INFORMATION SHEET

PROJECT TITLE GOLD SEAL AUTO TYPE OF SUBMITTAL new DRAINAGE PLAN
 ZONE ATLAS PAGE NO. J-20 CITY ADDRESS 921 EUBANK, N.E.
 LEGAL DESCRIPTION E 1/2 of BLK. 27, MESA VILLAGE ADD. 125.00' X 295.0'
 ENGINEERING FIRM LYNN ENGINEERING & SURVEYING CO. CONTACT GEO. RODRIGUEZ for DENNIS LYNN
 ADDRESS 12800 SAN JUAN, N.E. CITY PHONE 296-5978
 OWNER GOLD SEAL AUTO CONTACT MILTON SCALE
 ADDRESS 921 EUBANK, N.E. PHONE _____
 ARCHITECT DONALD A. JOHANSON CONTACT GEO. RODRIGUEZ
 ADDRESS 12800 SAN JUAN N.E. PHONE 296-5978
 SURVEYOR LYNN ENG. & SURVEYING CONTACT SAME AS ABOVE
 ADDRESS SAME AS ABOVE PHONE "
 CONTRACTOR LEONARD TAYLOR CONST. INC. CONTACT LEONARD TAYLOR
 ADDRESS 1020 EUBANK N.E. PHONE 268-8156

Pre-Design Investigation
(Additions)

SITE & DRAINAGE PLAN
(AUGUST, 1984)

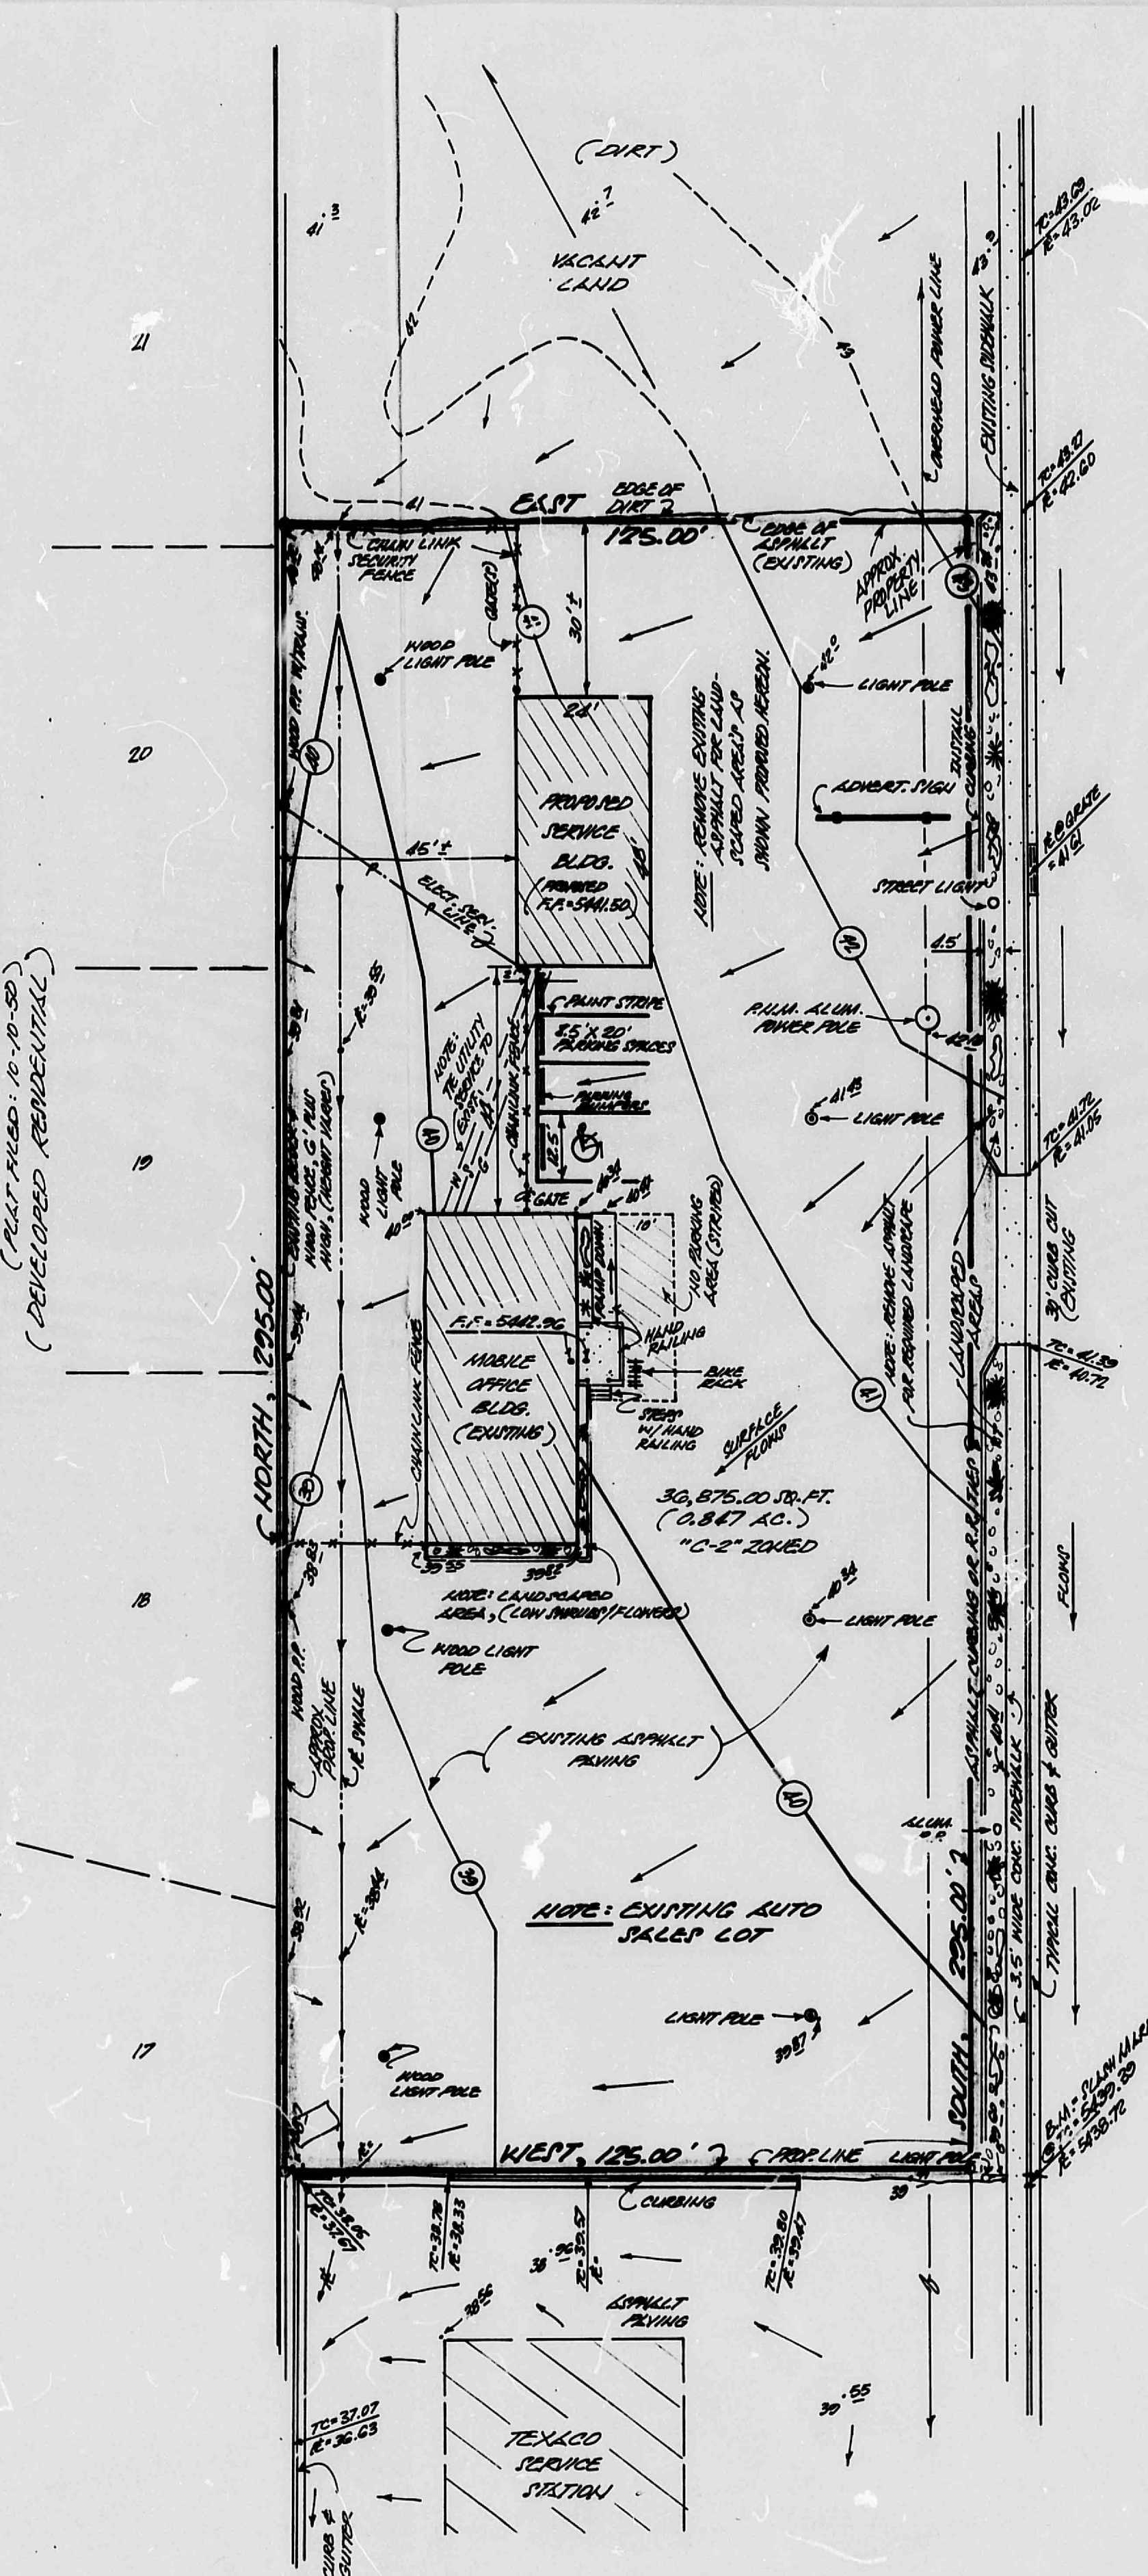
Plan Submitted Shows a good picture as to what is on site. Talk it over with Beane he said that Plan submitted is approved.

Advised George Rodriguez that the Plan in file need to be attached to Construction Set. and BWC would sign off on Building Plans.
